REPORT UPDATE

Application No: FG/198/16/PL

LOCATION: 1 Sea Drive
Ferring

PROPOSAL: Demolition of existing house with erection of 2 storey building comprising of 8No. residential 2 bedroom flats & associated external works

FRONT ELEVATION

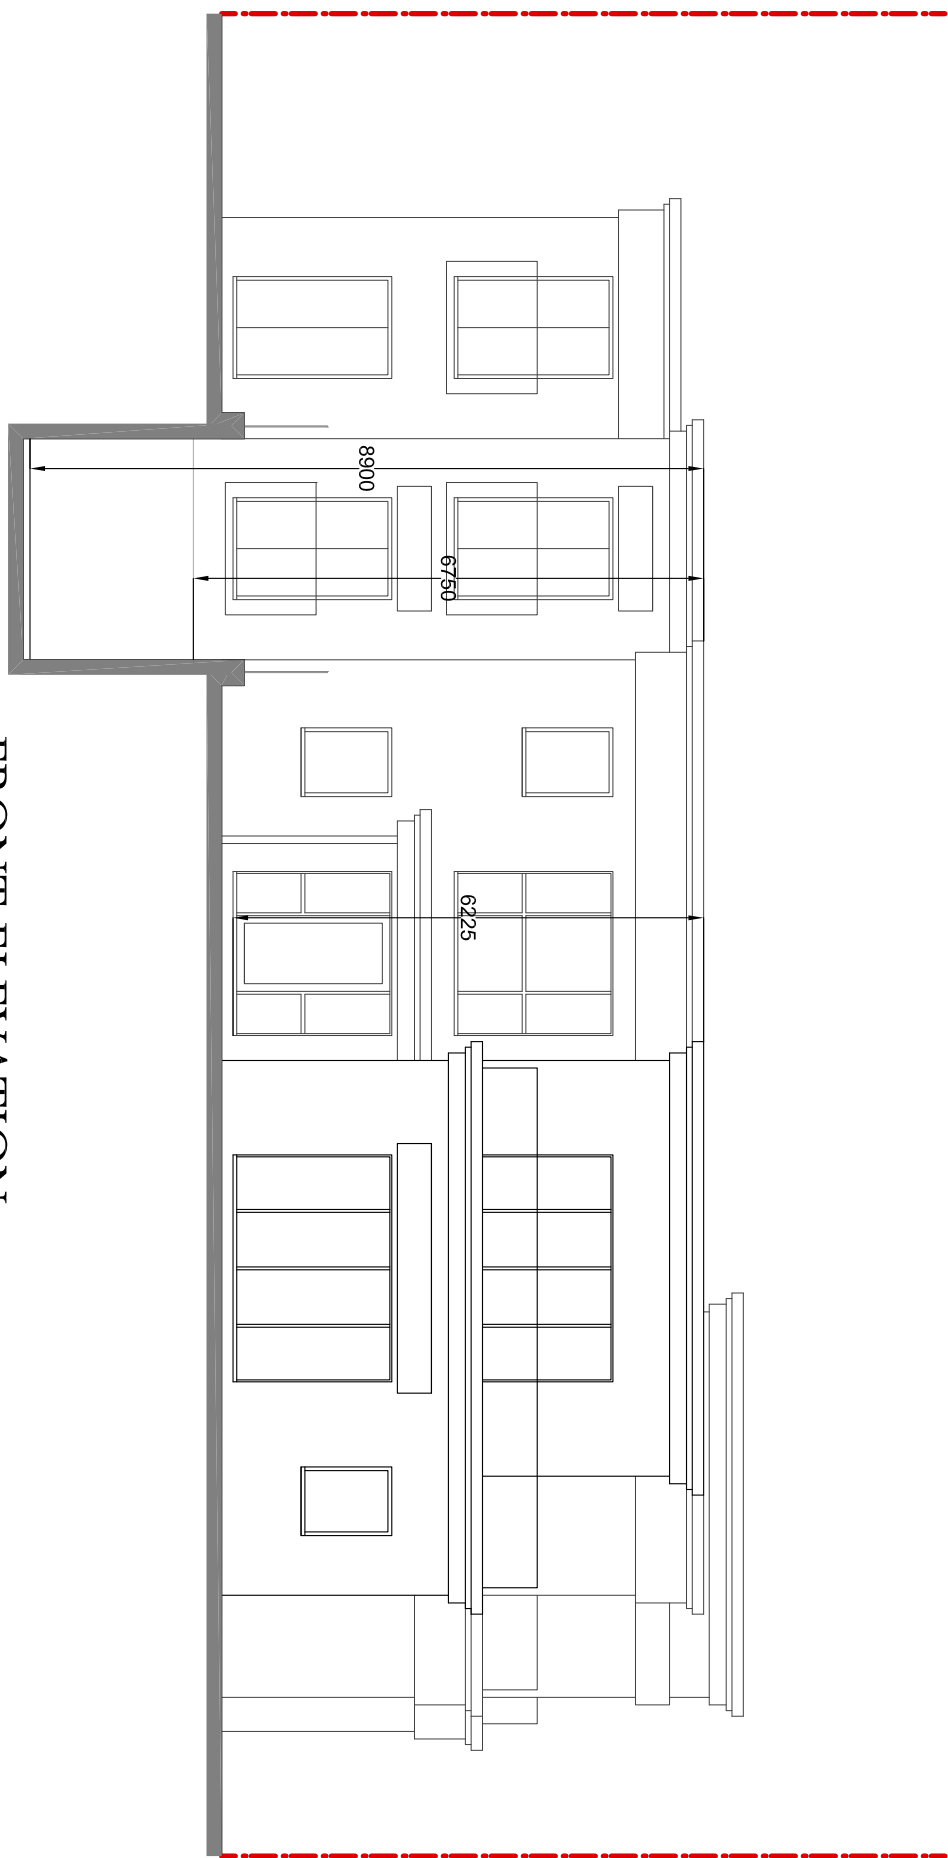
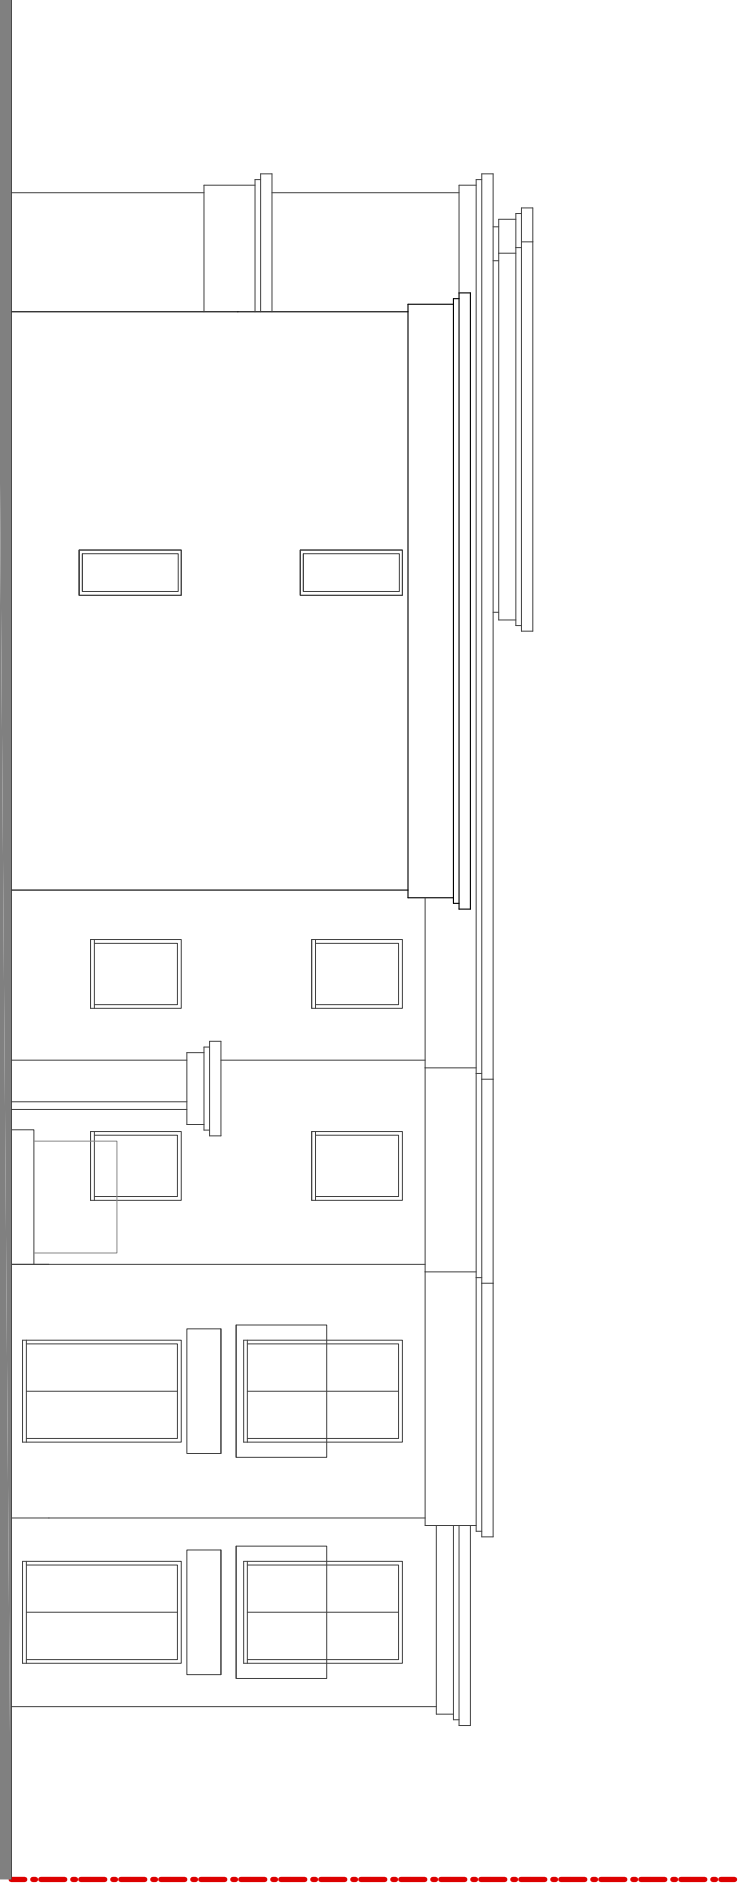
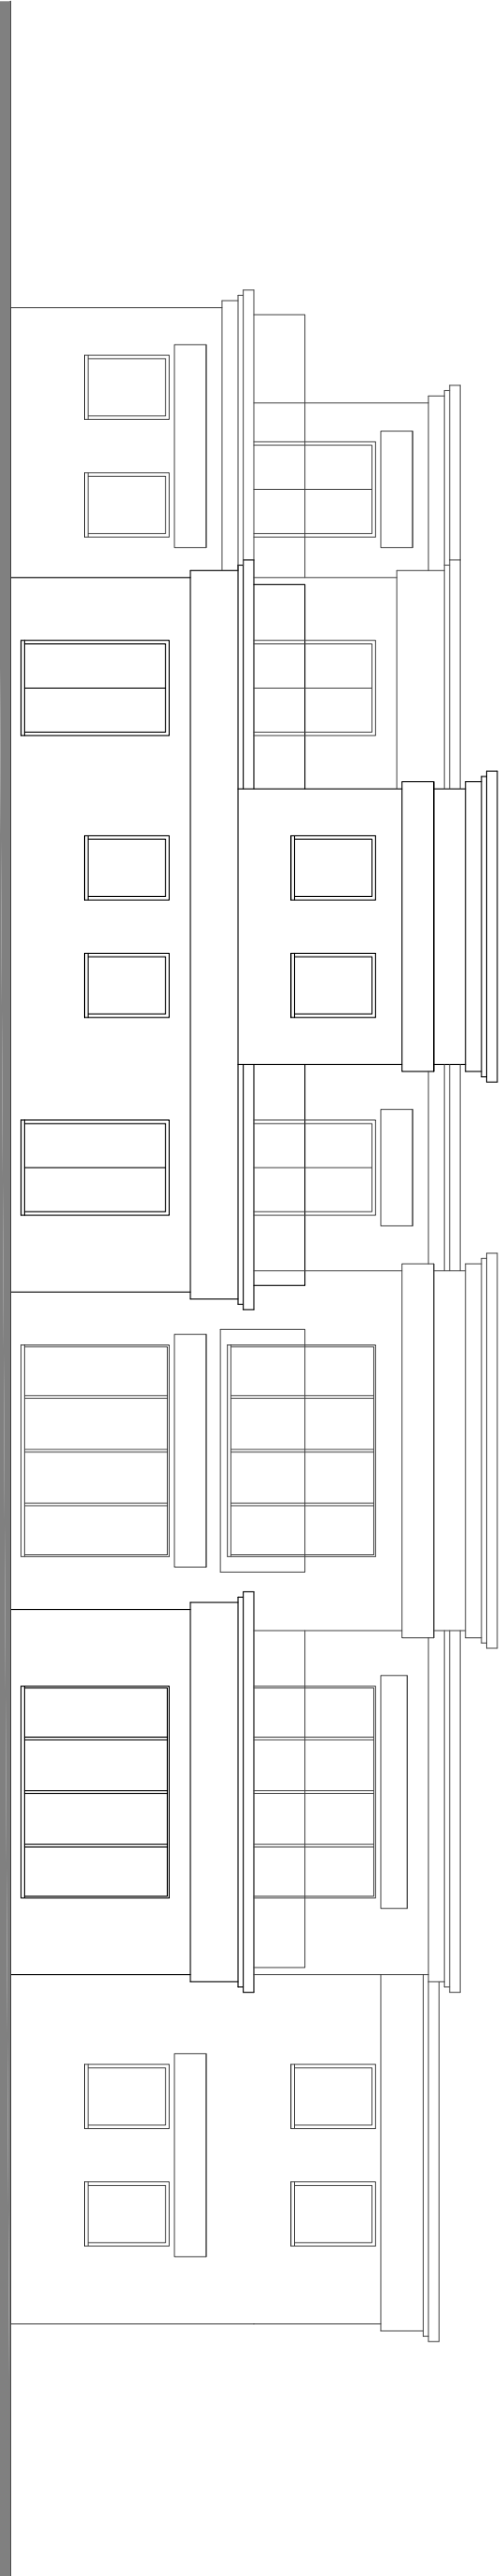
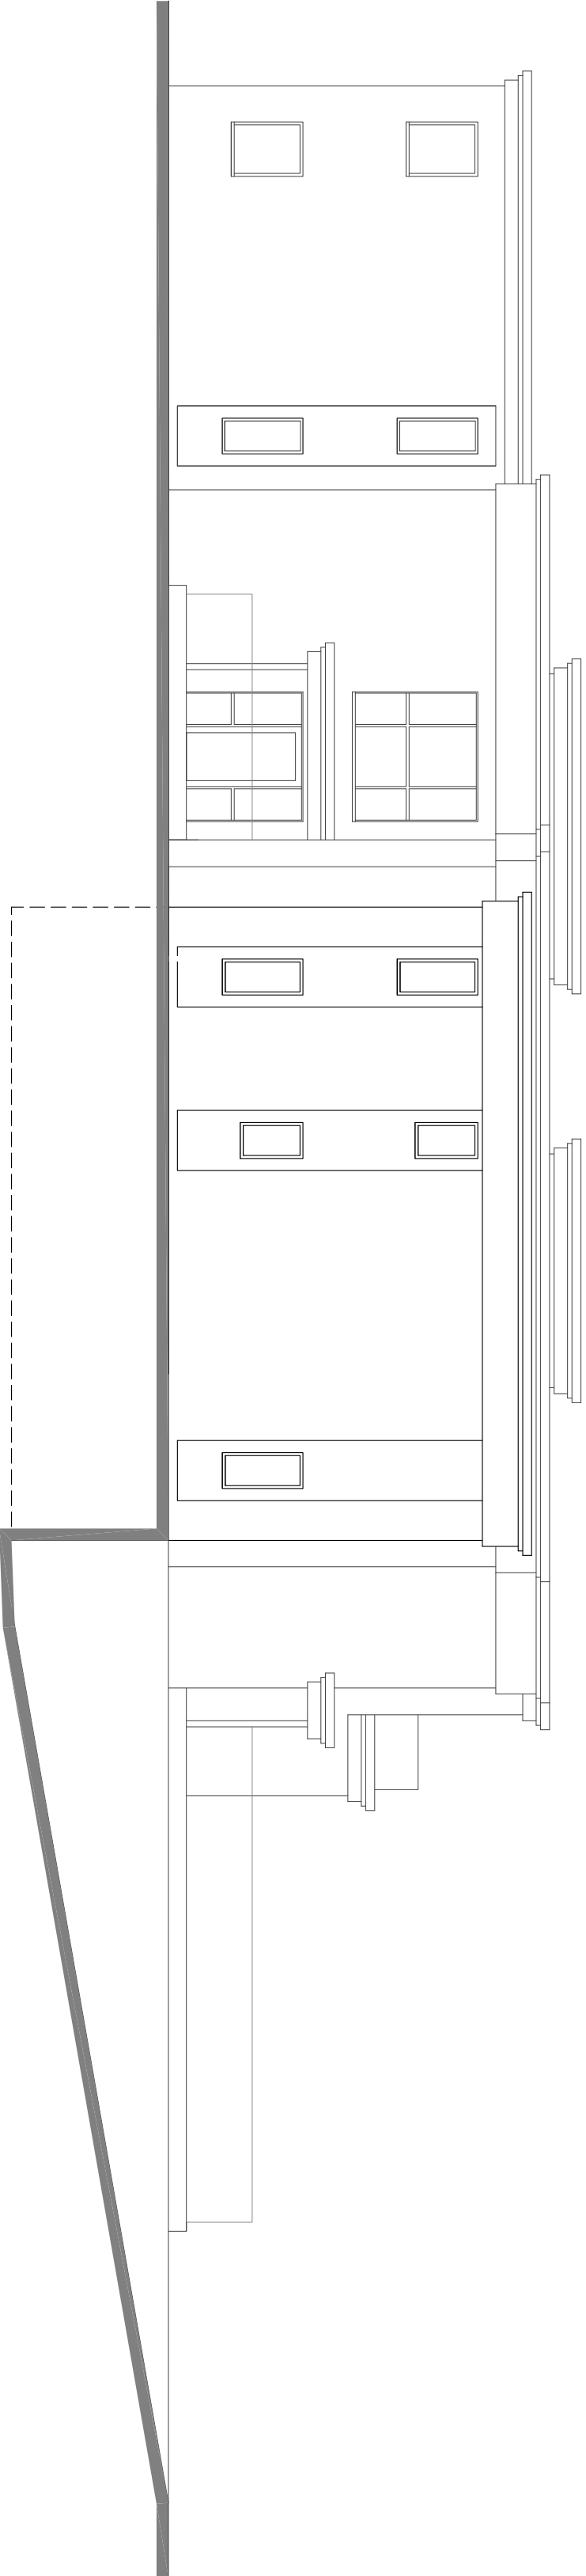
The height of the proposed block has raised 20 cm from the plans first submitted as shown on PL005 Rev J dated March 2017 due to the inclusion of the underground car park. The minor error (10cm) occurred in the response to Mr. Gann was due to line thickness on the plans.
